**Our ref:** AE/2018/123154/01  
**Your ref:** EN010079  
**Date:** 07 September 2018

**RELEVANT REPRESENTATIONS – NORFOLK VANGUARD OFFSHORE WIND FARM. NOTICE OF ACCEPTANCE OF AN APPLICATION FOR A DEVELOPMENT CONSENT ORDER. SECTION 56 OF THE PLANNING ACT 2008, REGULATION 8 OF THE INFRASTRUCTURE PLANNING (APPLICATIONS: PRESCRIBED FORMS AND PROCEDURE) REGULATIONS 2009 AND REGULATION 13 OF THE INFRASTRUCTURE PLANNING (ENVIRONMENTAL IMPACT ASSESSMENT) REGULATIONS 2009**

Sheet 16 of 27

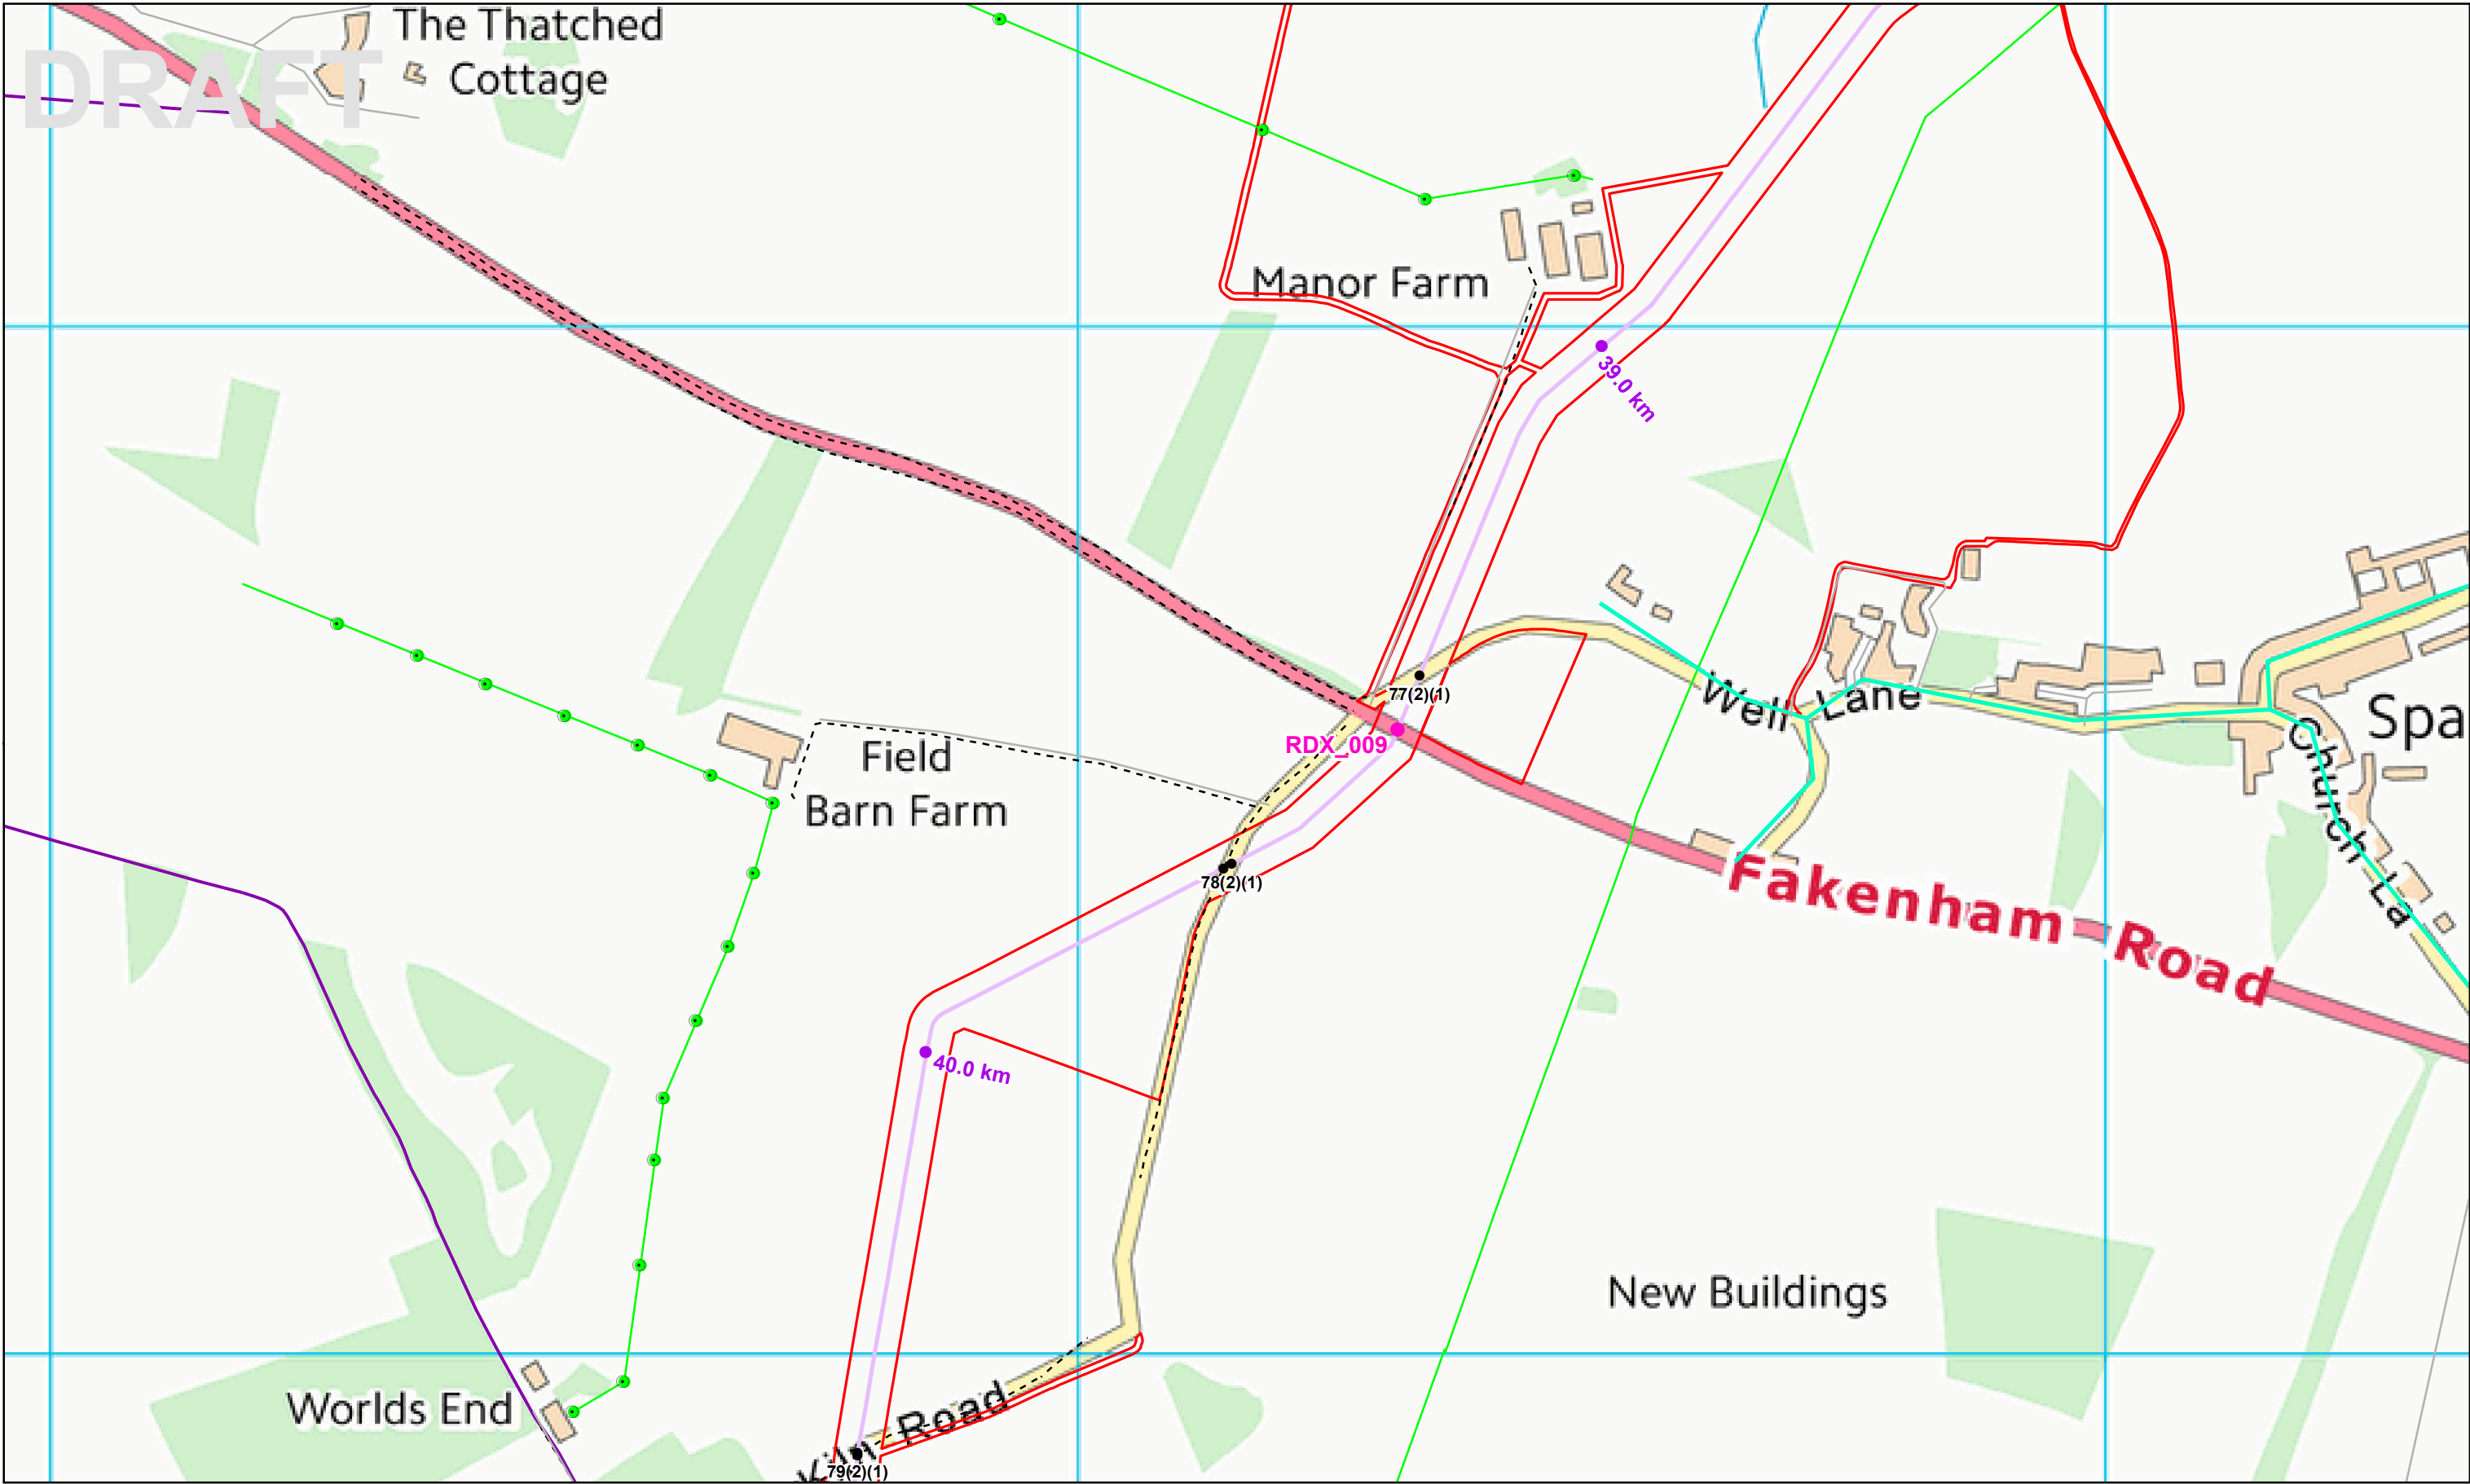
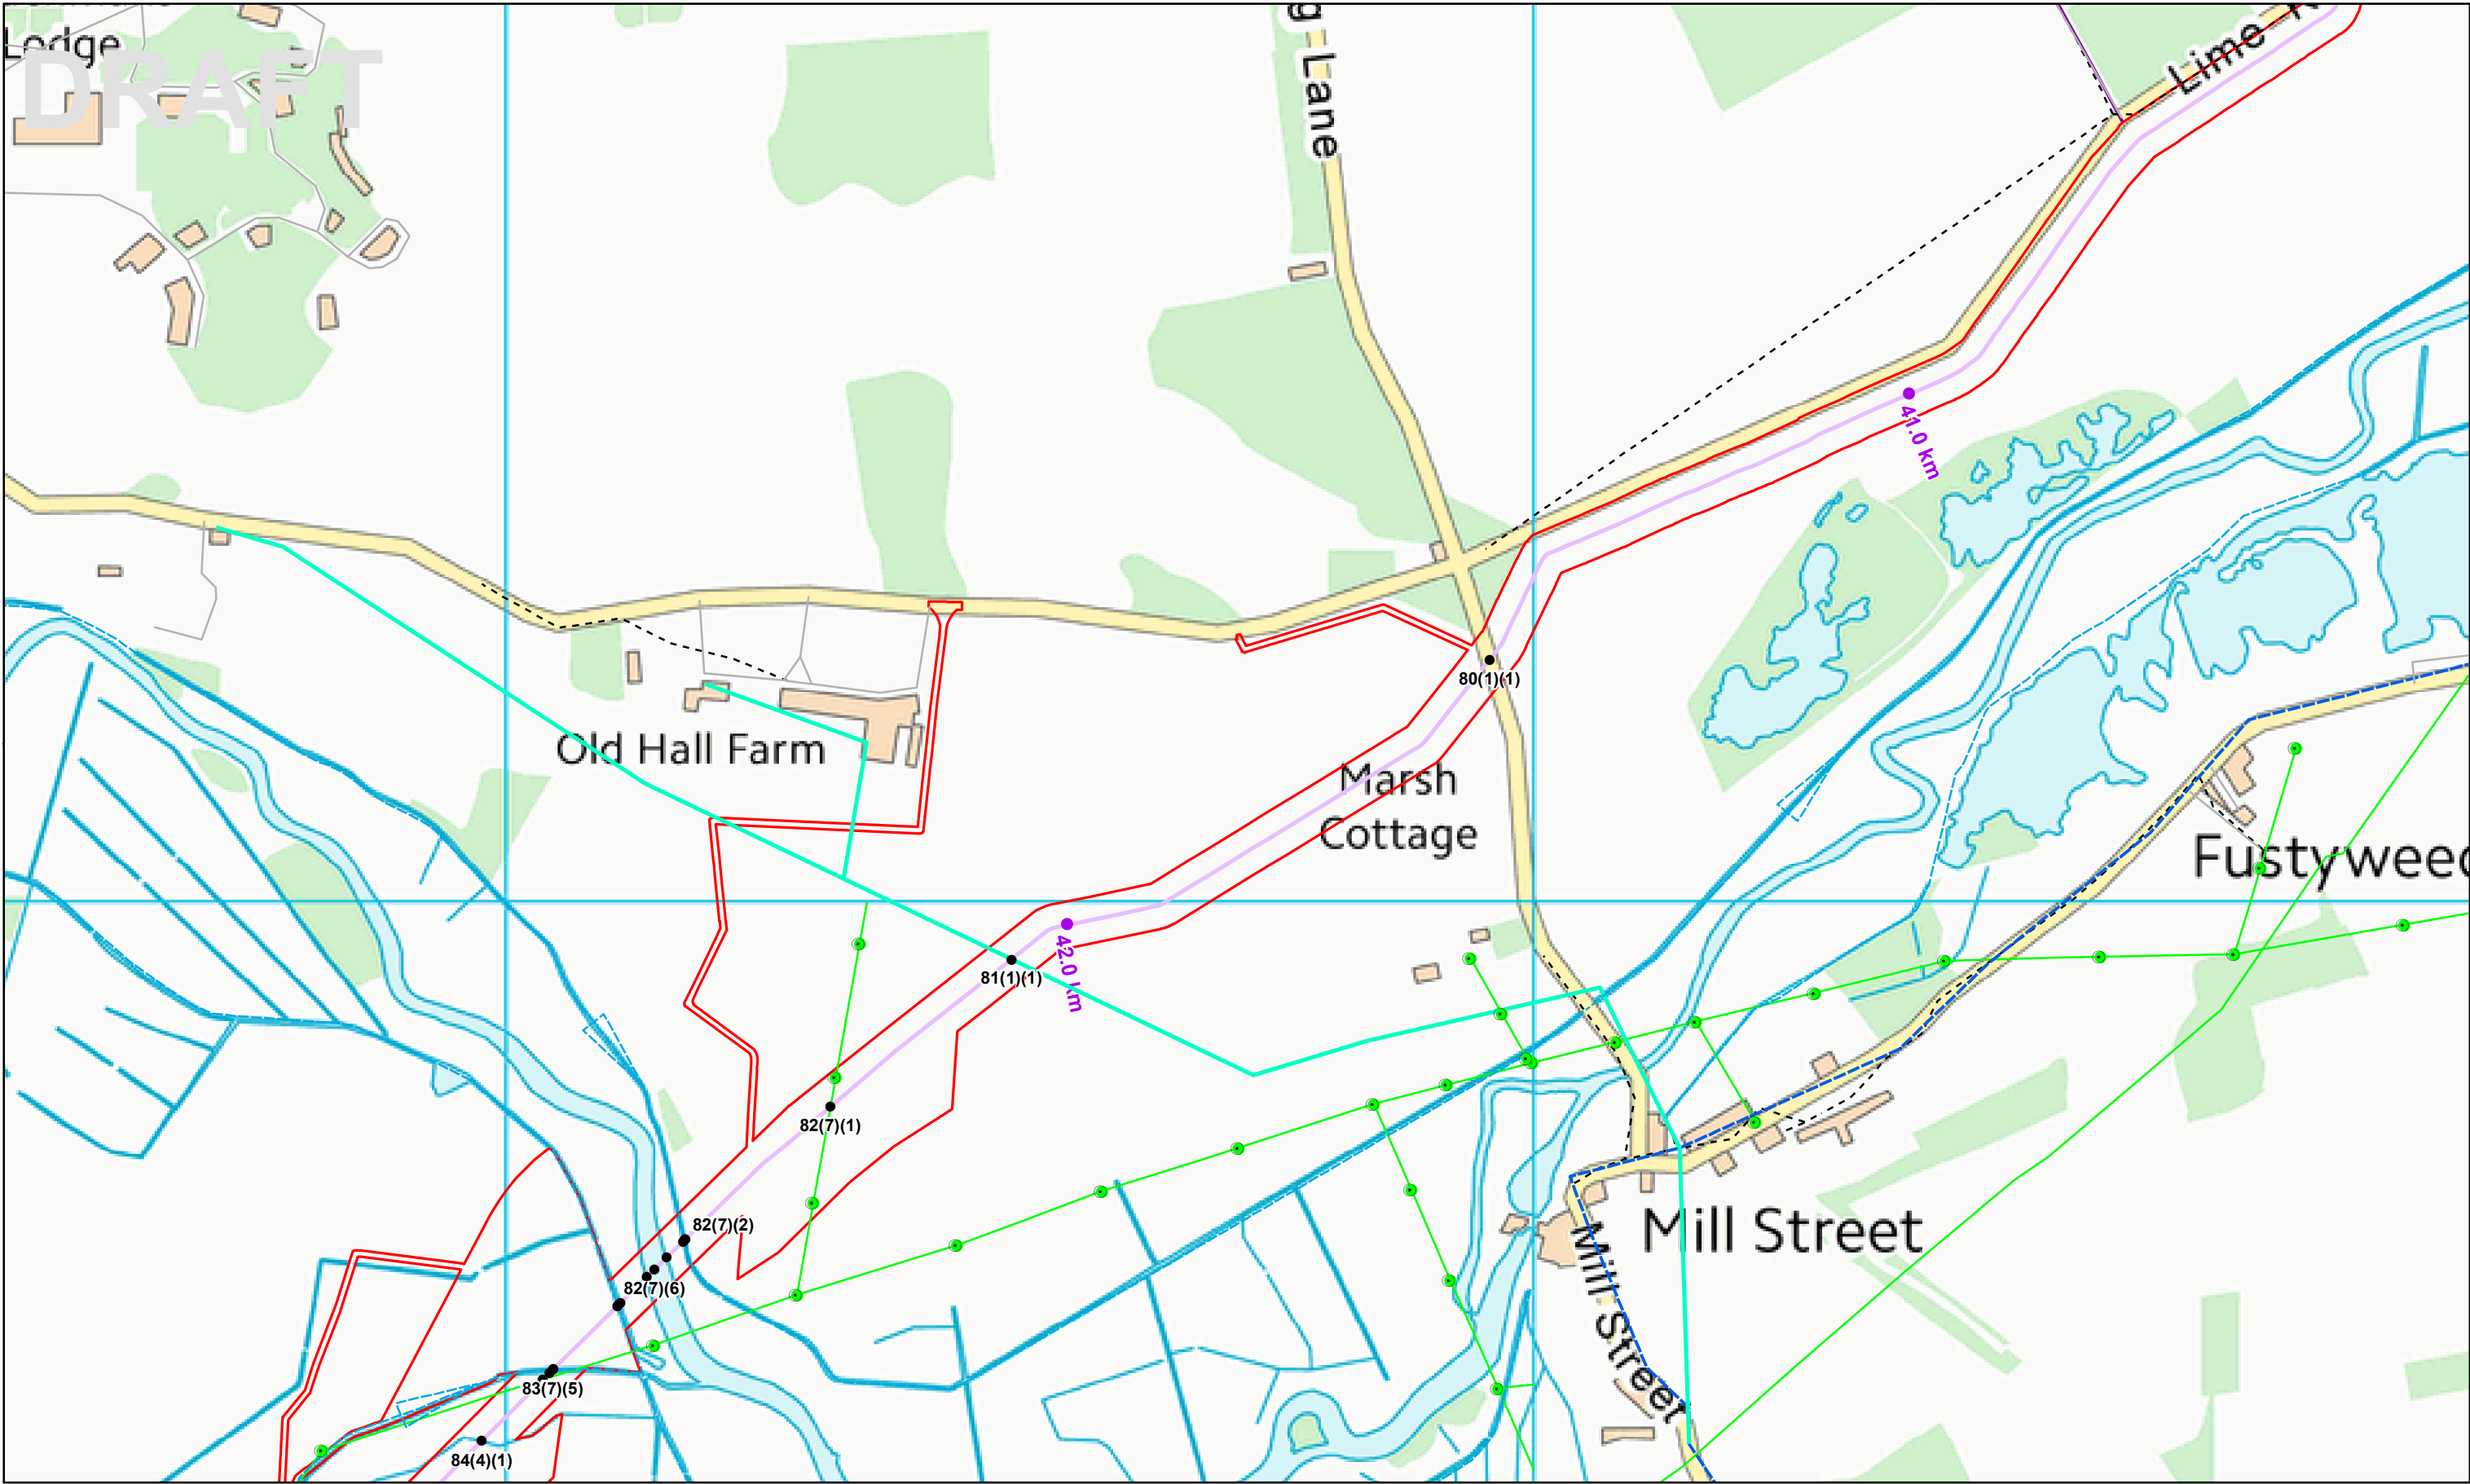
- 4.1 Table 20.1, Appendix 2.4 Detailed Watercourse Crossing Schedule, volume 3, sheet 16. The table shows that the Whitewater River is to be crossed by using open trench techniques.

- 4.2 The Whitewater River is a main river and the applicant will require an environmental permit unless the legislation relating to environmental permits is disapplied. For either of these options it will be necessary for the applicant to demonstrate that flood risk to the surrounding area will not be increased as a result of the works.
